Tween Bridge Solar Farm

9.13 Statement of Common Ground with South Yorkshire Fire & Rescue Service

Document Reference: 9.13

Revision 2~~1~~

Figure 2.9: Indicative Layout and Cross Section Plans
Drawing Ref: Typical Hammerhead Turning

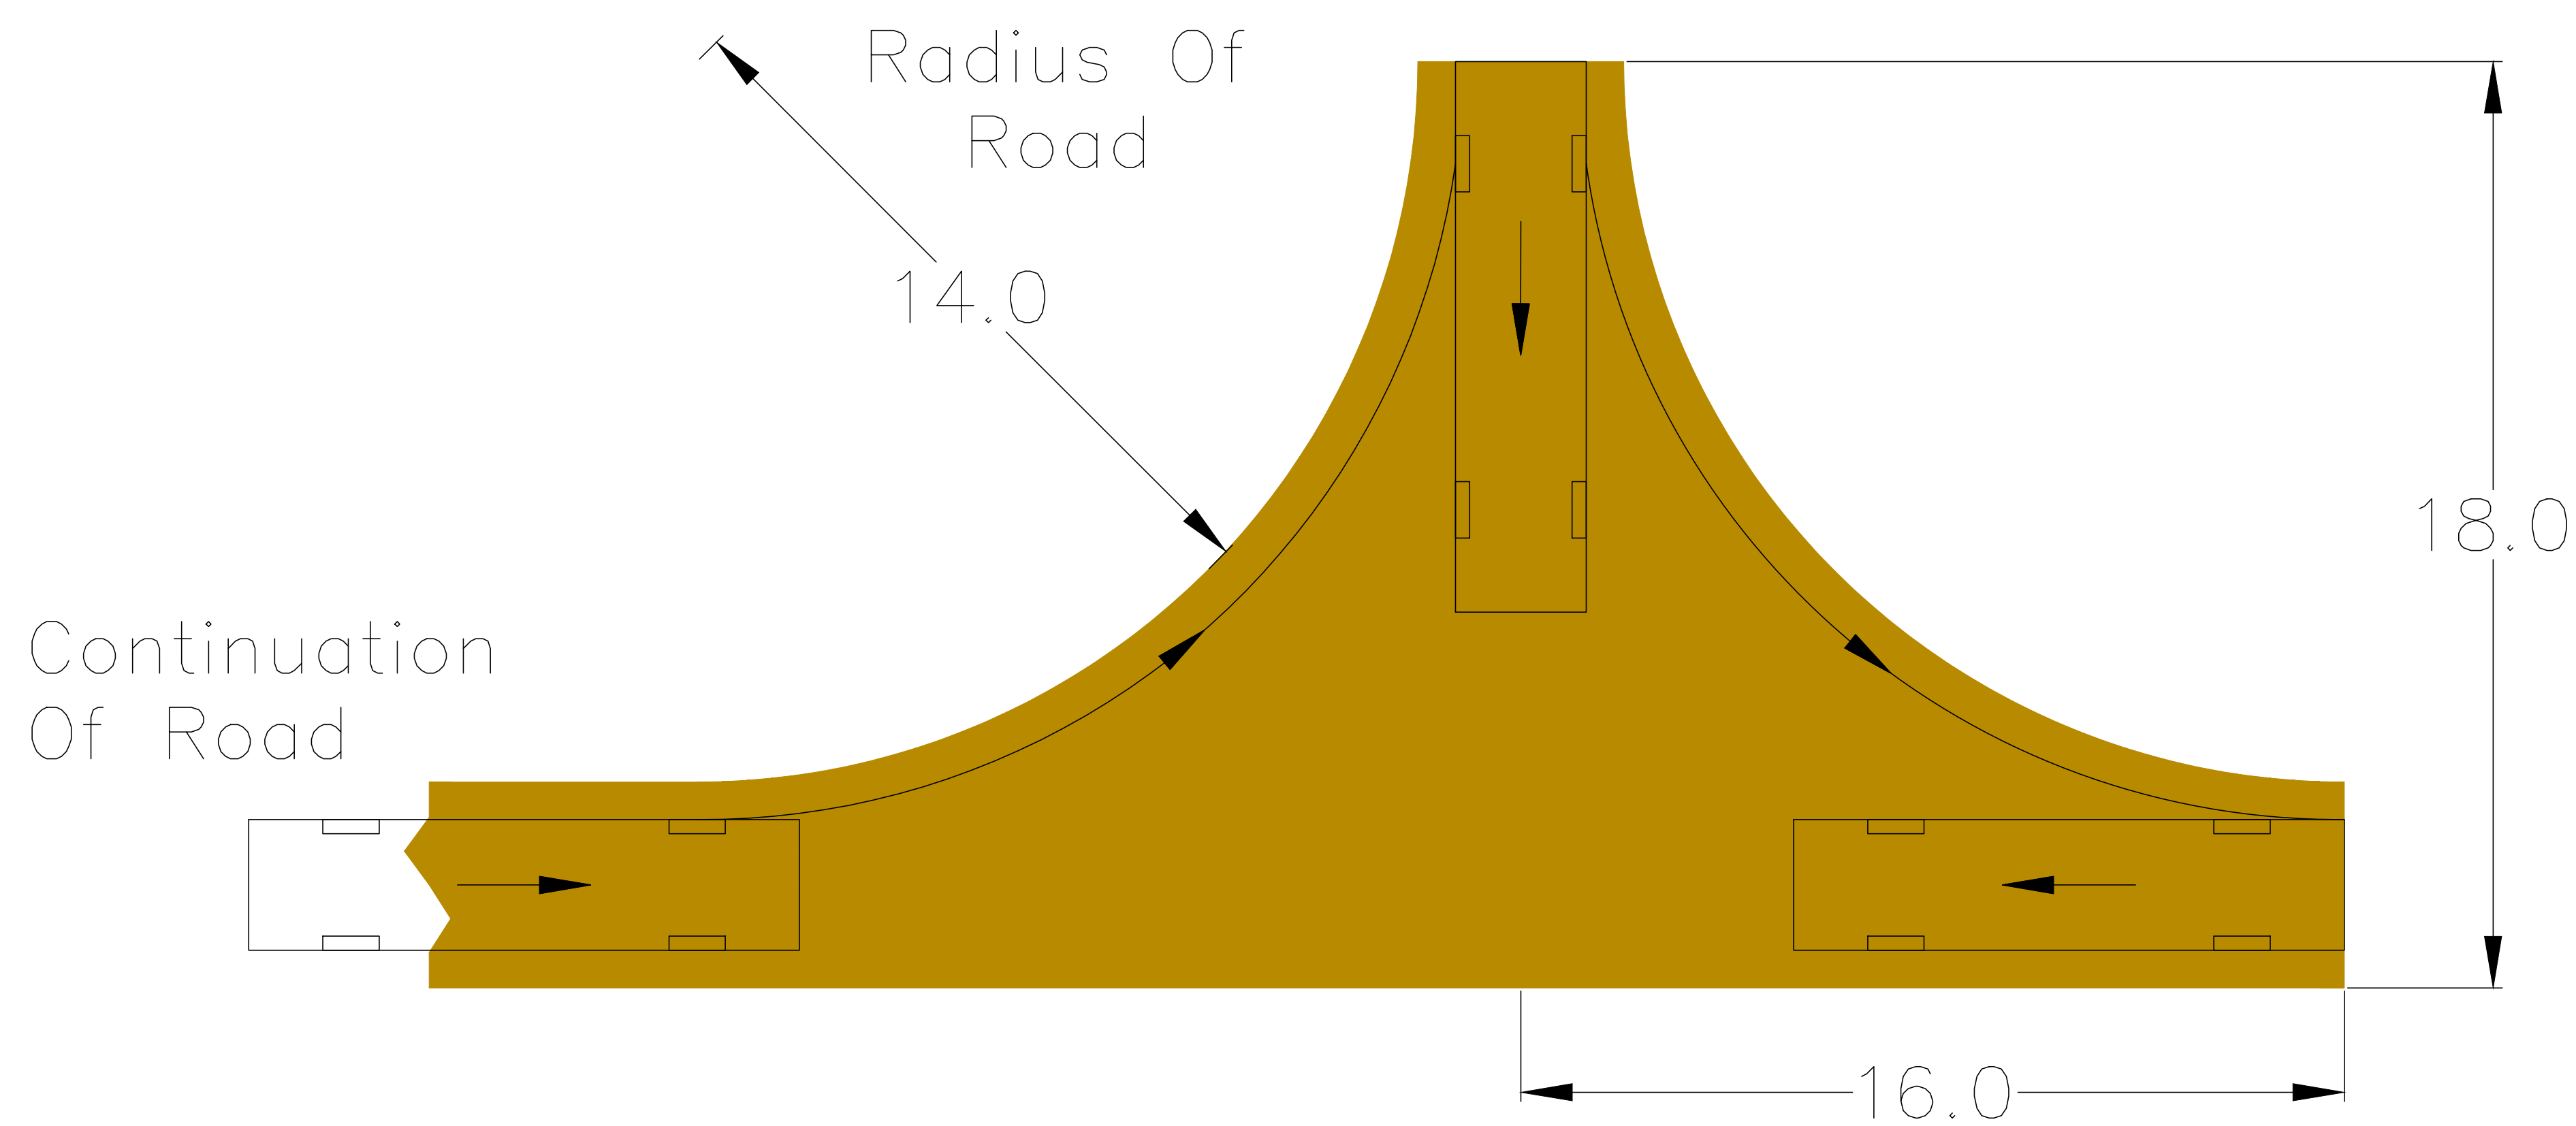
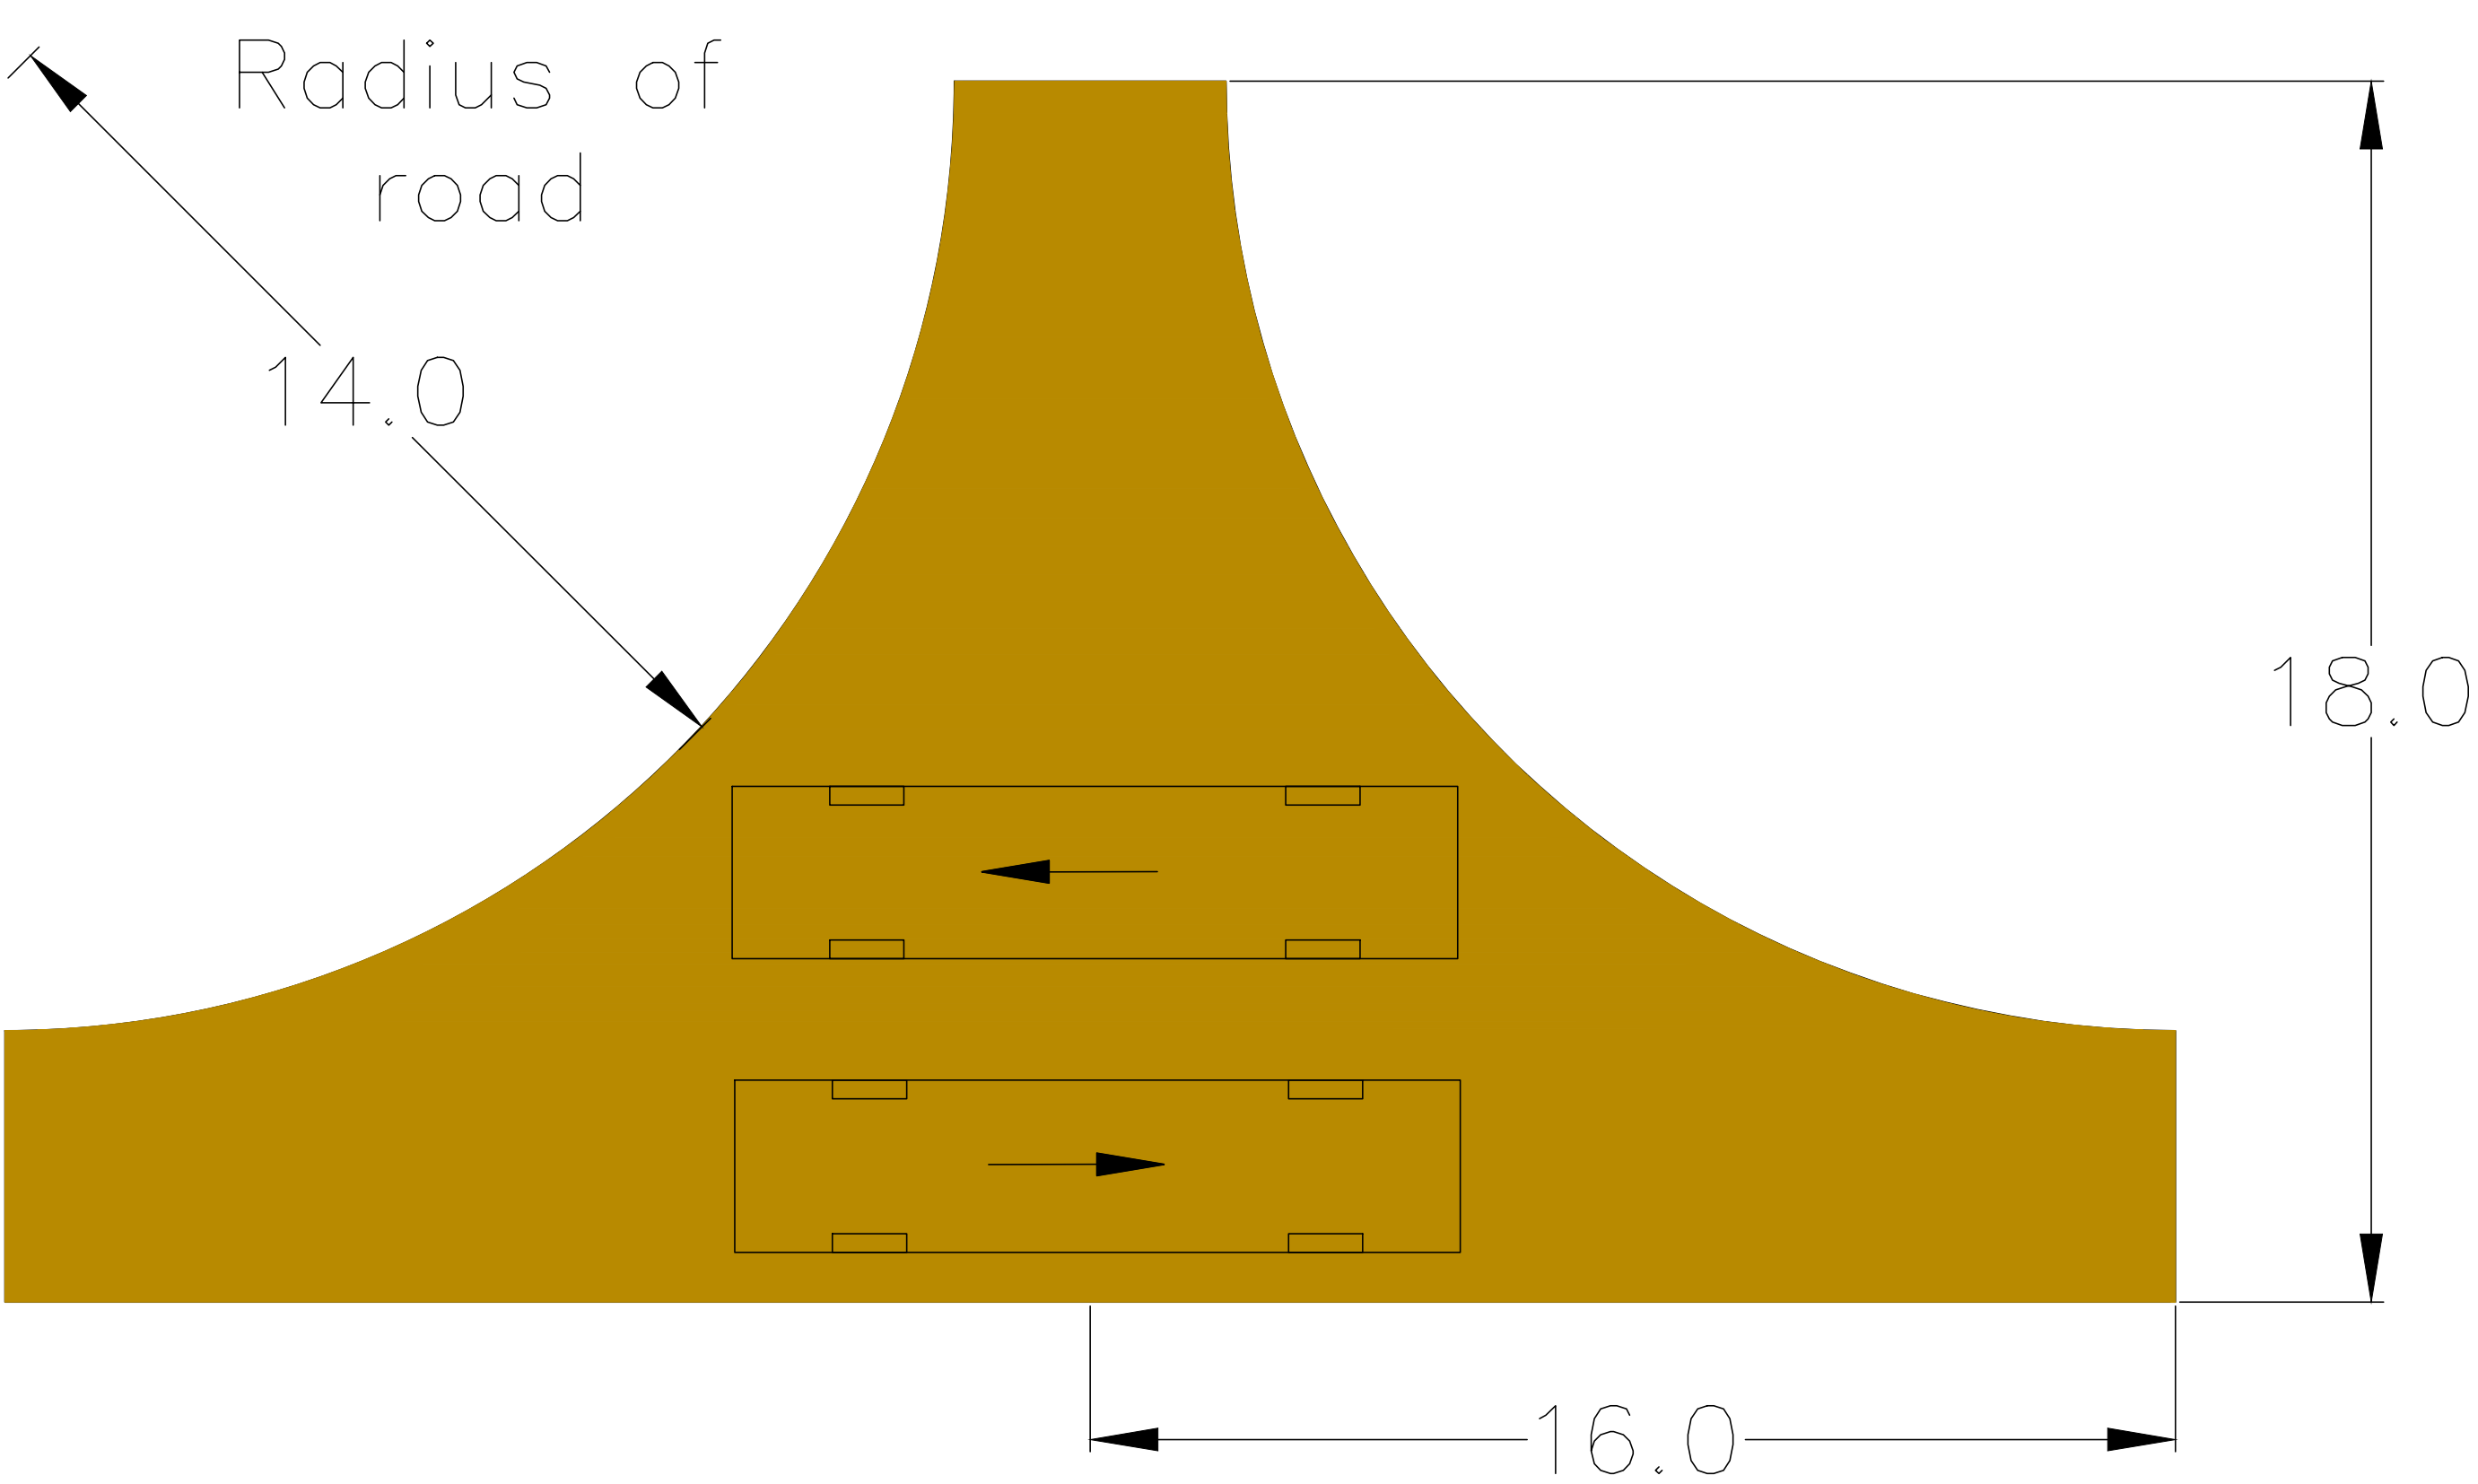
SYFR 4	Site Access	<p>The NFCC guidance states at least 2 separate access points to the site to account for opposite wind conditions/direction. Firefighters should not have to enter the BESS site or drive through a vapour / gas cloud to reach the scene of operation, therefore an alternative access point, taking into account wind direction, is preferable.</p> <p>The principles contained within Approved Document B, in support of B5 may assist in providing proportionate and adequate provision of access and facilities for firefighting. Section 15 provides information relating to access routes and hardstanding areas that consider the dimensions of fire service vehicles.</p> <p>Where access is over 20m from the access road, a turning circle, hammerhead or other point at which a vehicle can turn should be provided. Road / hard standing should be suitable to accommodate fire service vehicles in all weather conditions.</p> <p>Appliance dimensions are variable and designers should take account of this.</p> <p>SYFR appliance dimensions for the current fleet are as follows:</p>	<p>The Scheme is compliant with NFCC guidance as confirmed in the Outline BSMP [Document Reference 7.4 Revision 2APP-179].</p>	Agreed
